Our Ref RG/SPRUSTINGTON6.1
Your Ref A/23/15/OUT

Mixed-Use Development on Land south of A259 New Road and East of Brook Lane, Angmering, West Sussex

We write, on behalf of our client Store Property Investments Ltd to comment on the proposed development at the above site. Specifically, our comments below are in relations to the Road Safety Audit Report (RSA1) undertaken by Fenley Partnership on the 6th April 2015 and uploaded onto the Arun District Council planning portal on the 4th June 2015.

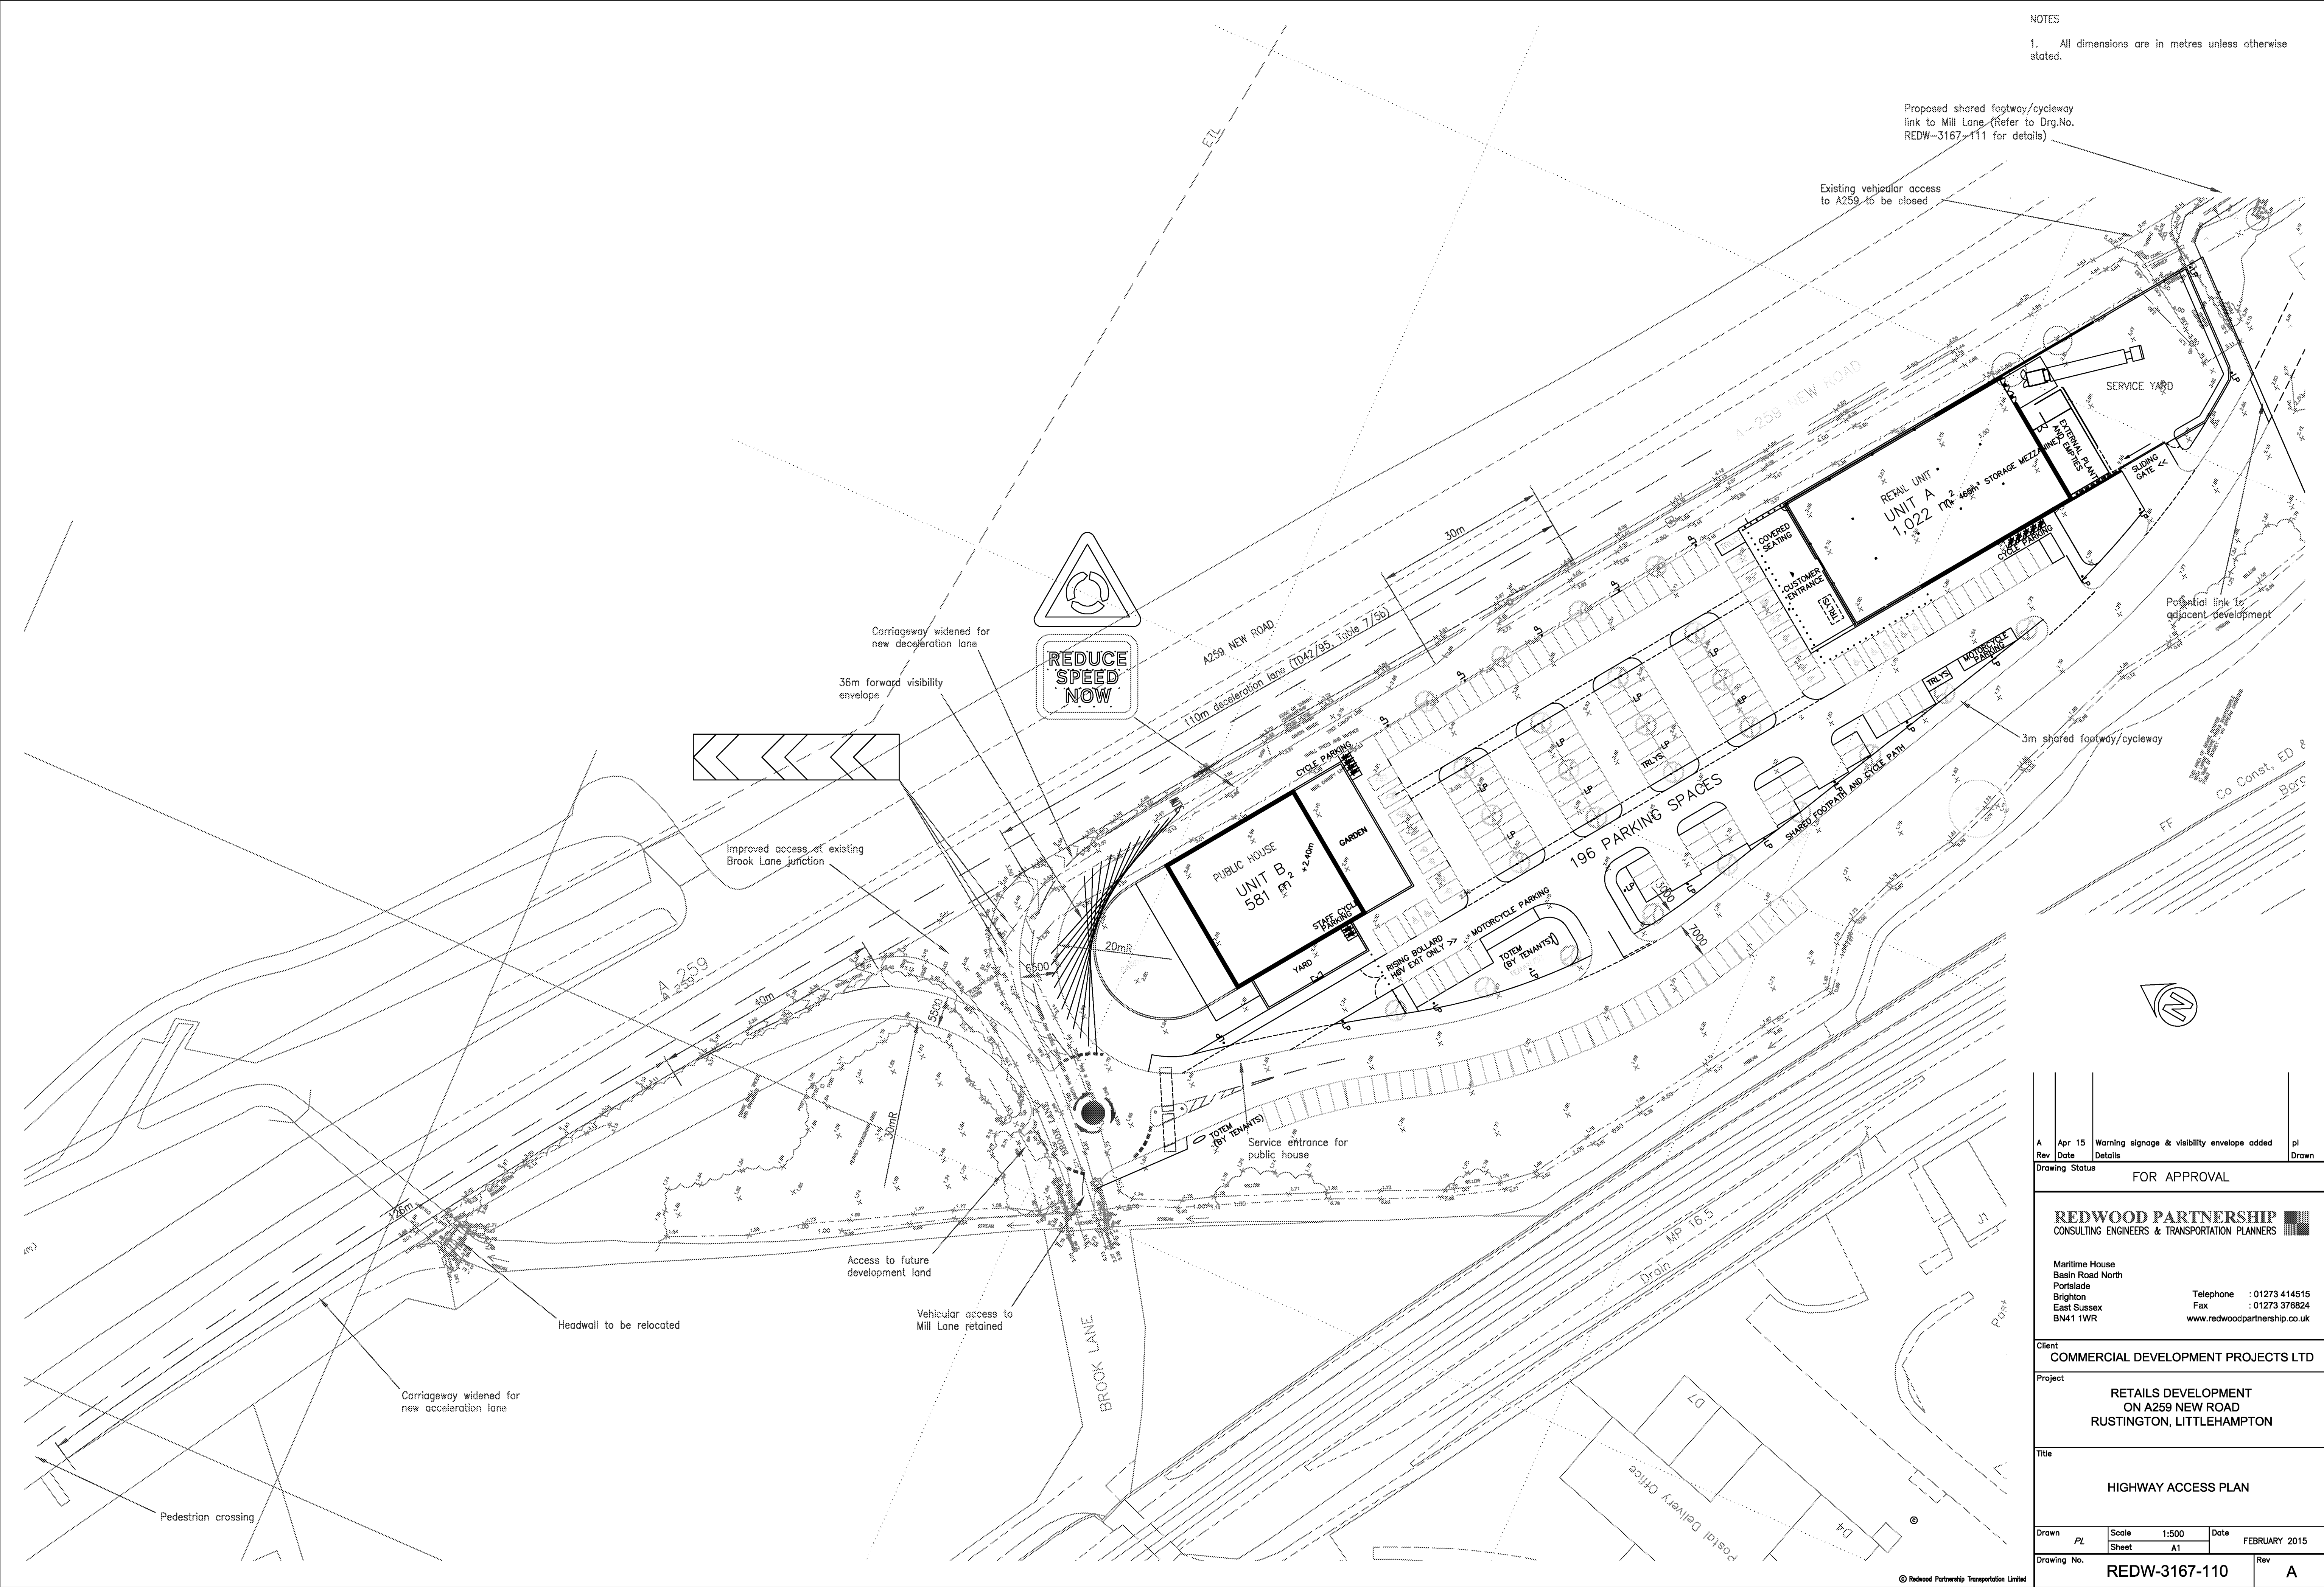
- A.2.1 Tight entry corner radius – states that vehicles could be travelling at speeds in excess of that required to safely negotiate the 20m radius, suggests chevrons and warning signs that the designer agrees to and provides drawing illustrating this. We would suggest that it is questionable whether this is sufficient mitigation to justify the departure from standards;
